**From:** Tom Errico <thomas.errico@tylin.com>  
**To:** Jean Fraser <JF@portlandmaine.gov>  
**CC:** "Margolis-Pineo, David" <DMP@portlandmaine.gov>, Katherine Earley <KAS@p...>  
**Date:** 4/29/2015 1:34 PM  
**Subject:** 1342 Congress Street/Jewish Community Center -- Preliminary Traffic Comments

Jean - I have reviewed the application materials and the following summarizes my preliminary traffic comments.

CONCRETE WHEELCHAIR ACCESSIBLE RAMP
NOT TO SCALE

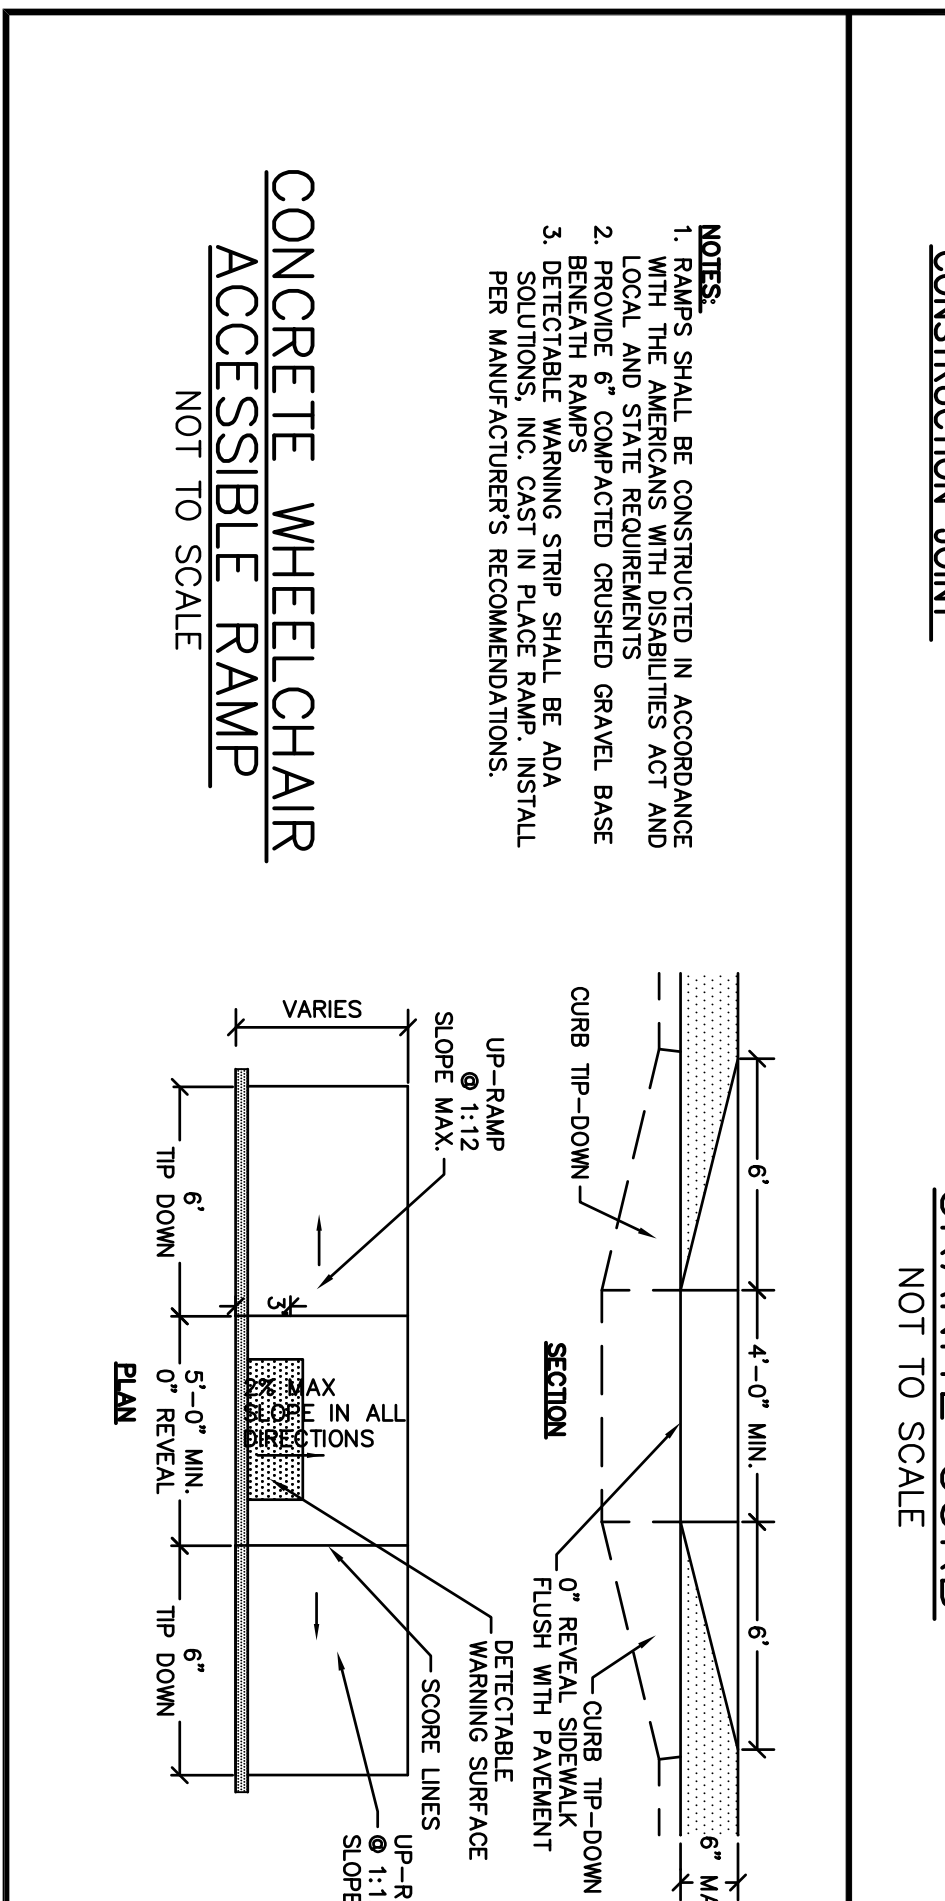
\* A detectible warning panel is not required at the site driveway on Congress Street.

OVERALL SITE PLAN

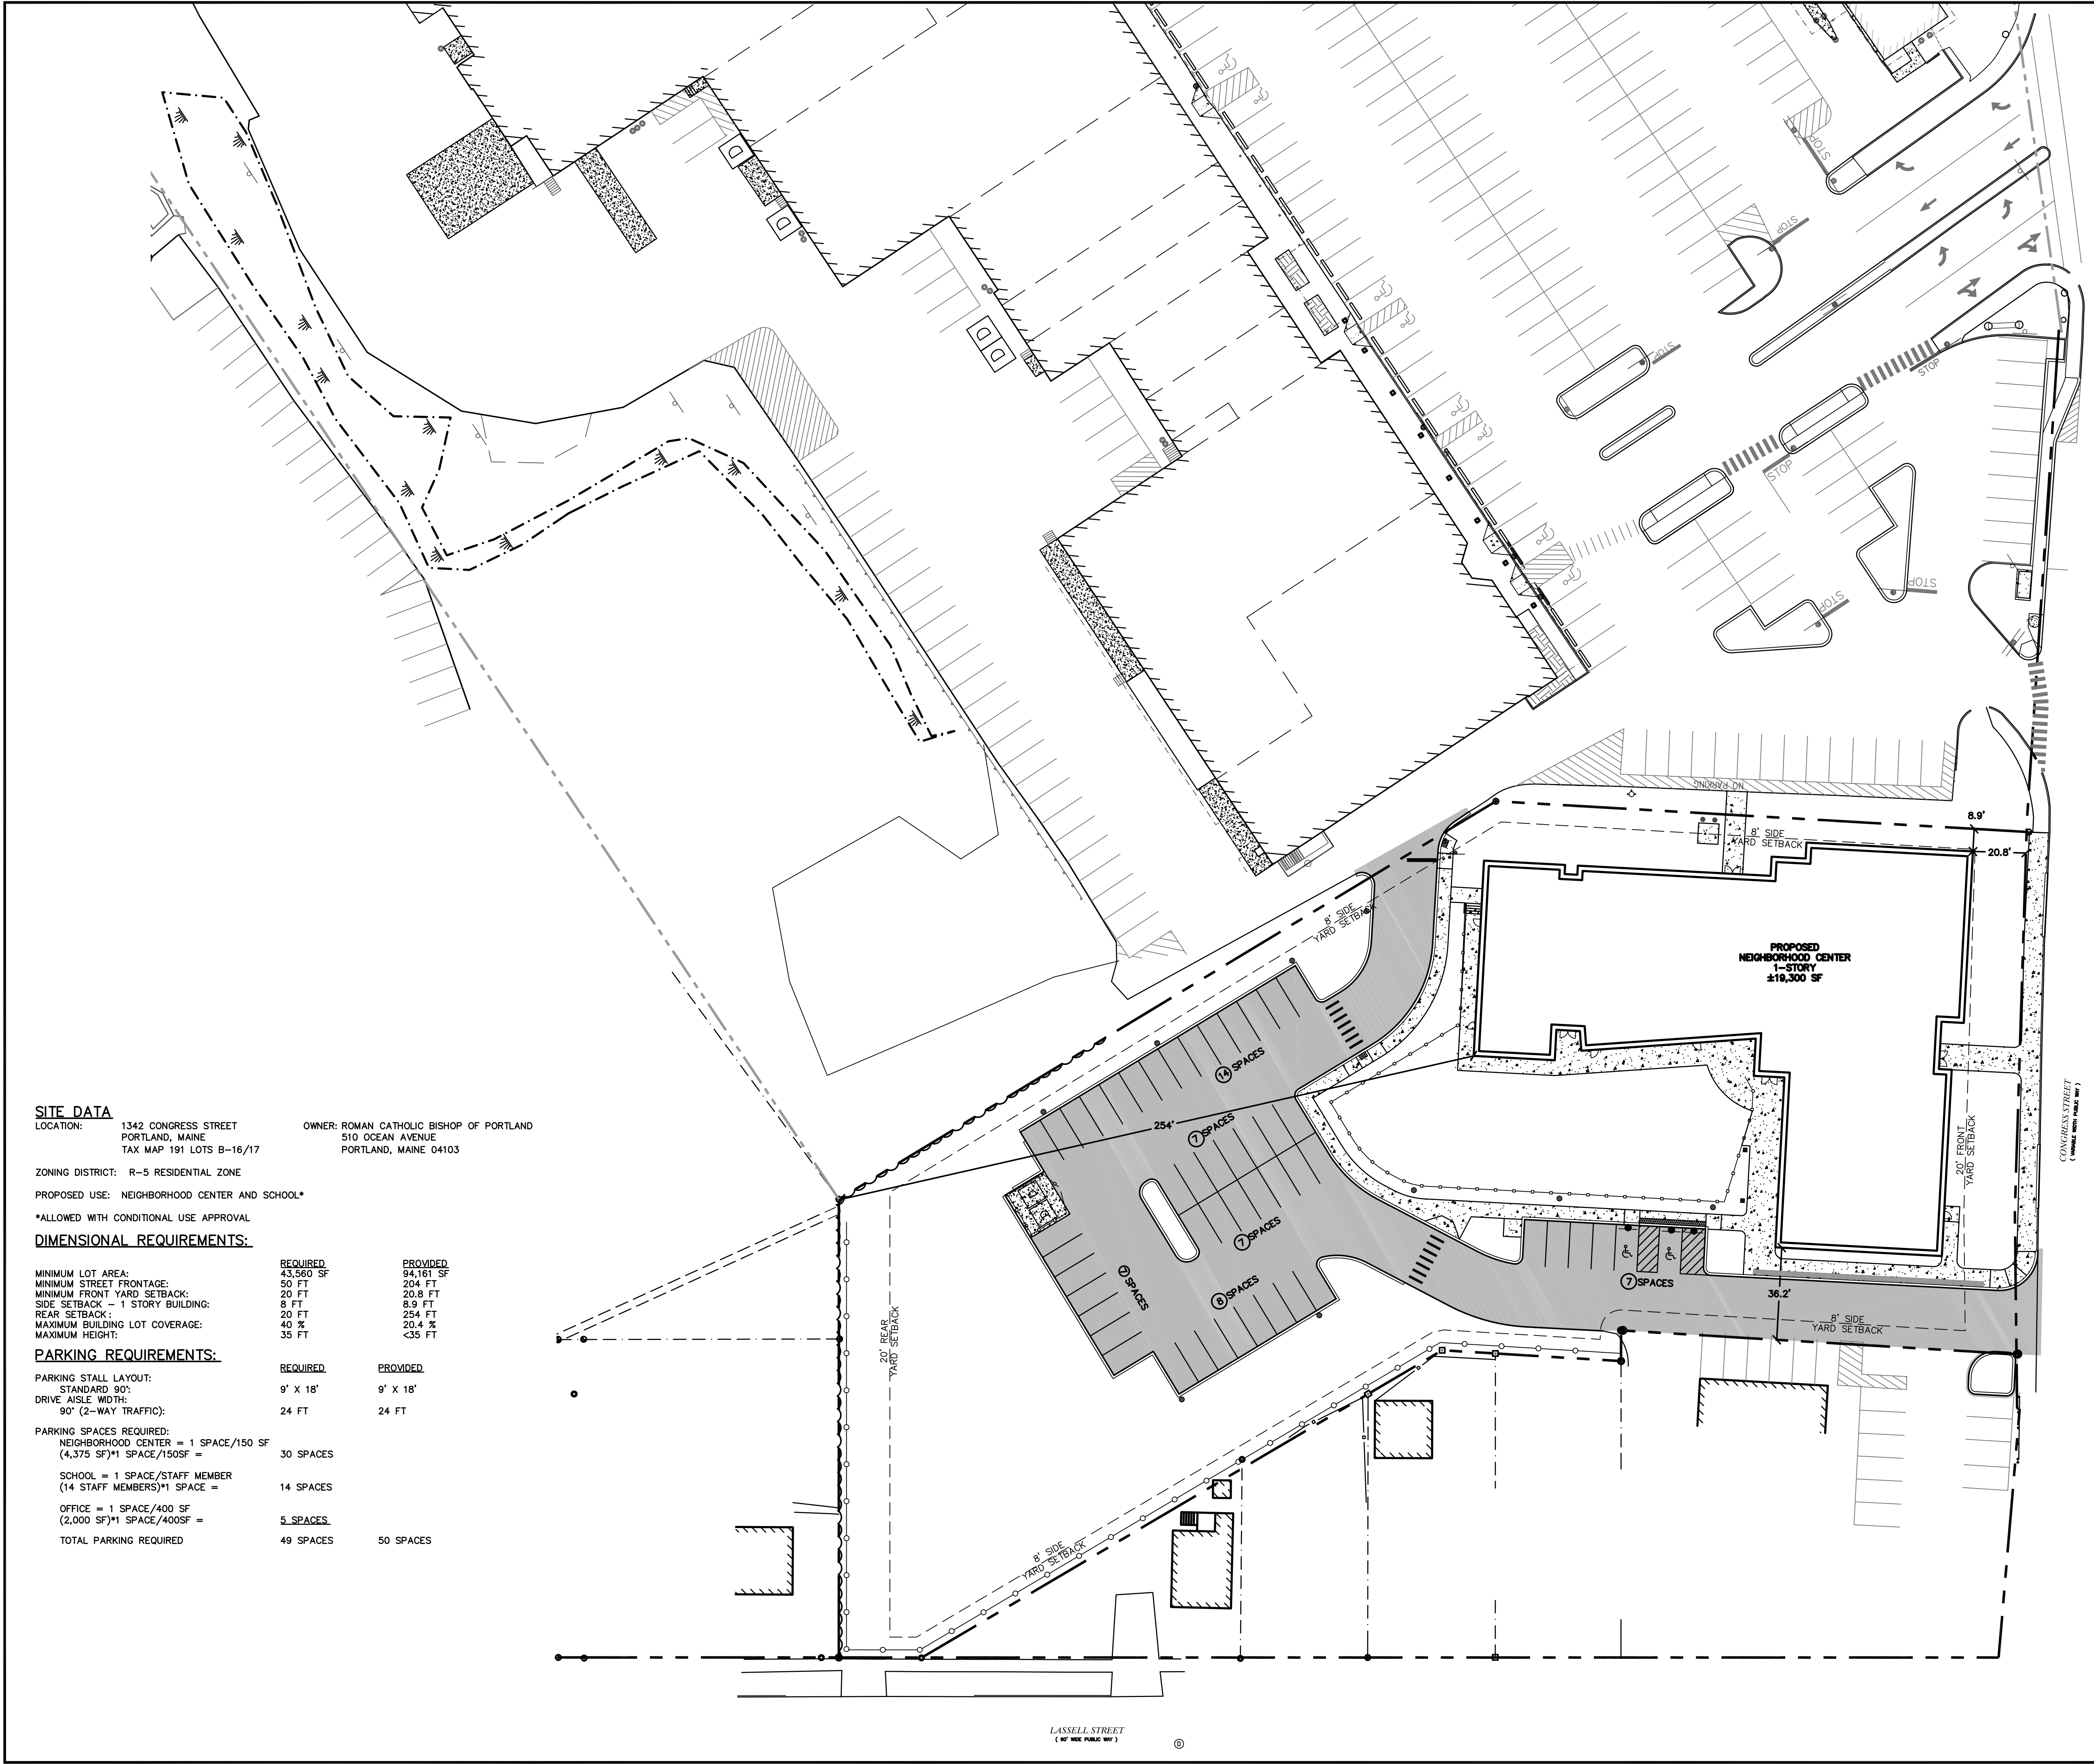
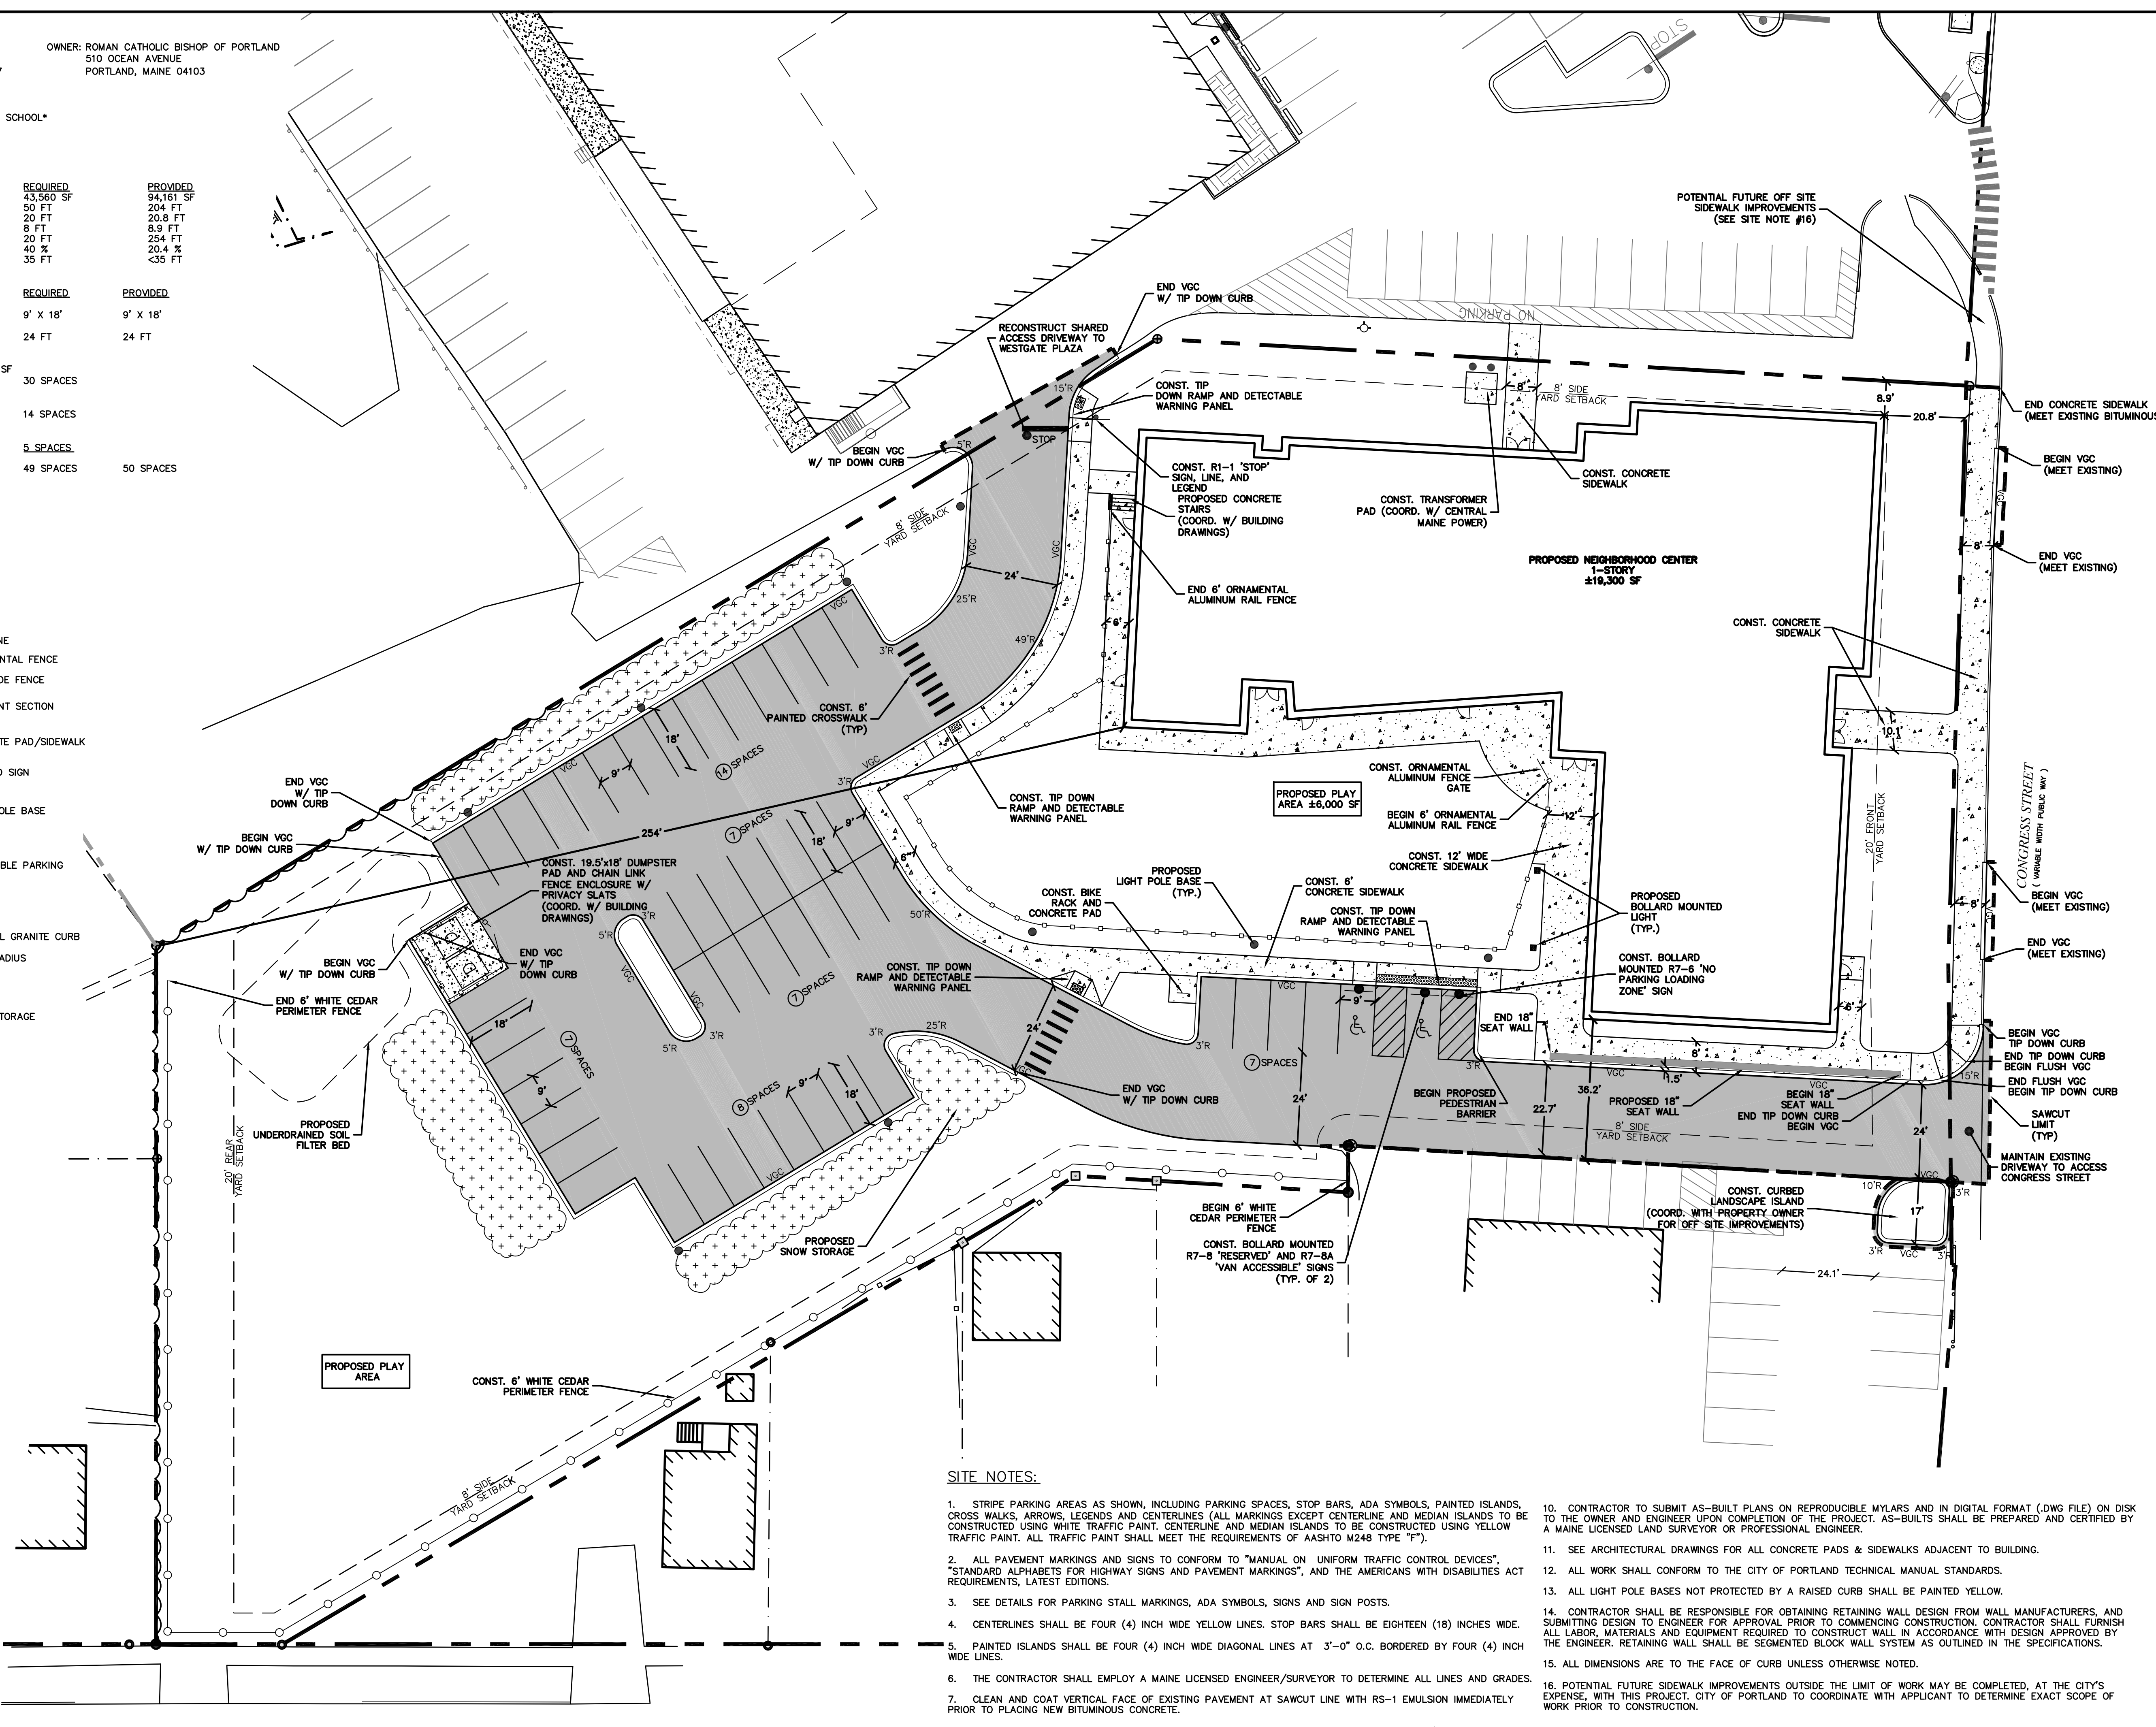
\* The driveway entering the site from Congress Street is noted as having a width of 22.7 feet. This width (in the area where parking maneuvers occur) does not meet City standards and thus a formal waiver should be requested by the applicant.

\* I find the vehicular connection to Westgate Shopping Center to be an excellent access management strategy that will allow traffic from the Community Center to utilize the traffic signal at Stevens Avenue. I would note that this connection can also serve traffic from the abutting medical office building and traffic from Lassell Street. Accordingly, I would suggest that access use rights be provided. While I would prefer that the connection to the Westgate Shopping Center to be more direct, given the potential for vehicle/pedestrian conflict, the proposed plan appears acceptable. The applicant should provide a response on this issue and how they see traffic circulation interacting with site activity.

\* The applicant shall consider the formal delineation of the driveway along the medical office property boundary, when entering from Congress Street.
